Our Ref CRTR-PLAN-2018-
24875
Your Ref 18/00825/HYBRID

Proposal: Demolition of buildings and structures as listed in Schedule 1; Outline planning permission for mixed use redevelopment, the continuation of use of areas, buildings and structures already benefiting from previous planning permissions, as specified in Schedule 2; associated infrastructure works including surface water attenuation provision and upgrading Chilgrove Drive and the junction with Camp Road

Location: Heyford Park, Camp Road, Bicester

Waterway: Oxford Canal

FIGURE 9 PEDESTRIAN AND CYCLE CONNECTIONS

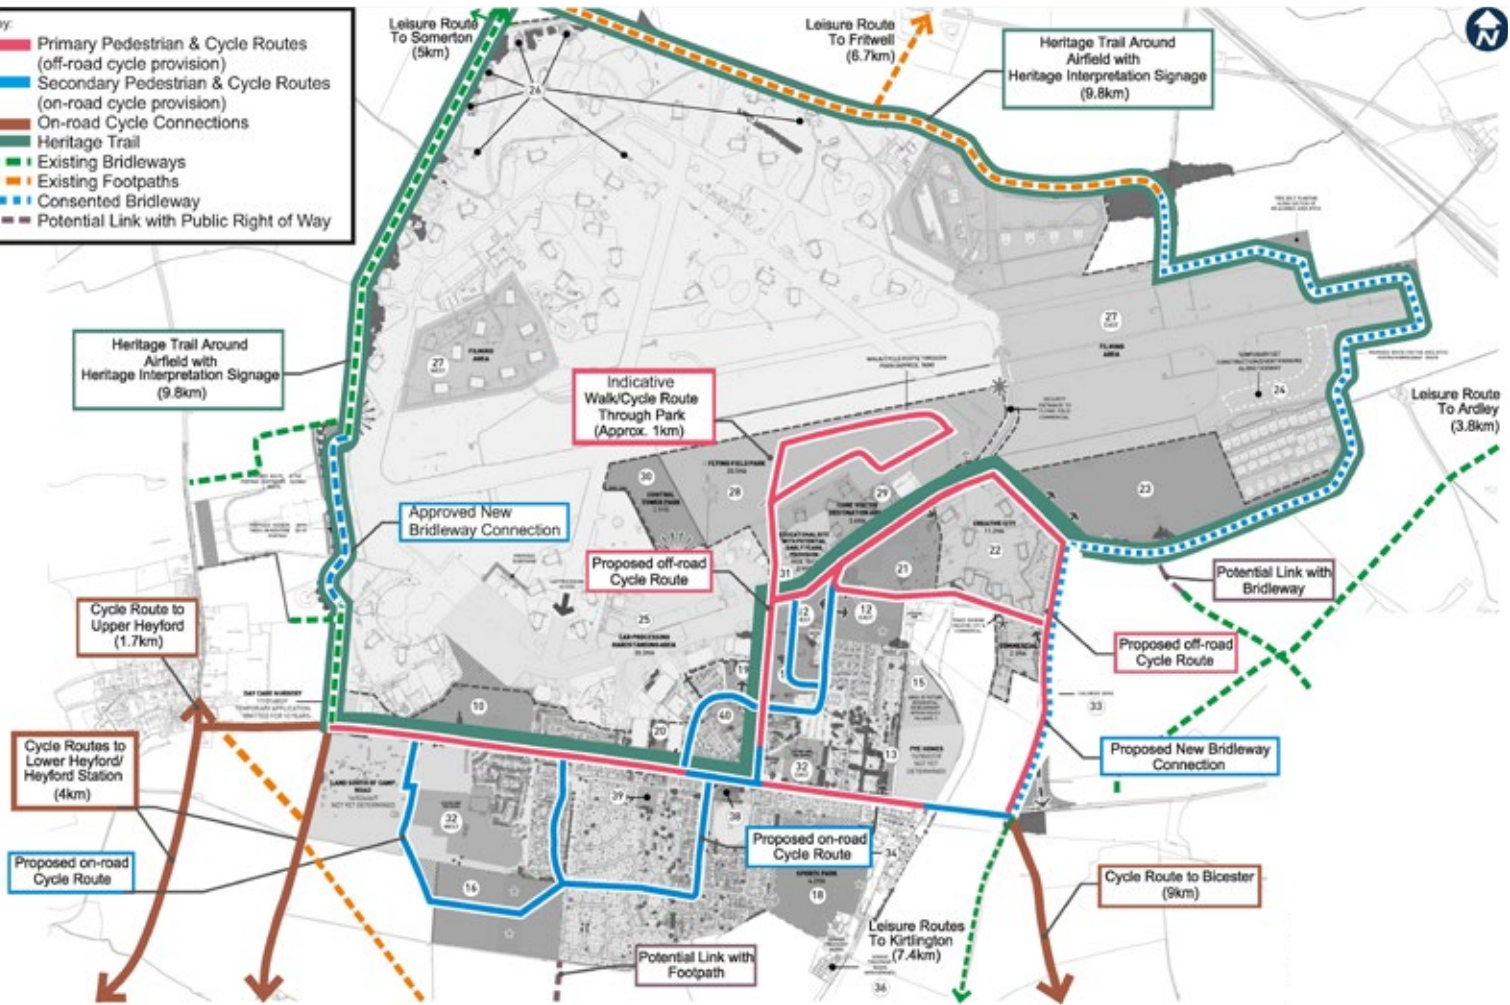
The Design & Access Statement refers to links to existing green infrastructure as an opportunity for the redevelopment of the site and the submission references cycling routes to the station though this does not appear to include the towpath. The proposed Portway footpath should link to the canal and there should be a clear route from the public park in the centre of the development to the towpath. The towpath is accessible from the site and would provide an important off-street alternative for cyclists.

The need for improved signage is referenced in the application and this is a positive aspect though it should be ensured that this includes signage to the canal. As highlighted above the canal will provide a number of benefits to physical and mental wellbeing for future residents and a sustainable off-road transport route.

However, in order to achieve this, it is important to ensure there are clear links between the site and the canal and it is fully integrated with the development at this stage. A stronger emphasis on the canal as part of the Green infrastructure/ sustainable transport links for the development should be included. In addition, there needs to be a stronger emphasis on cycle parking and more focus on the door-to-door journey in the sustainable movement section of the Green Infrastructure Strategy.
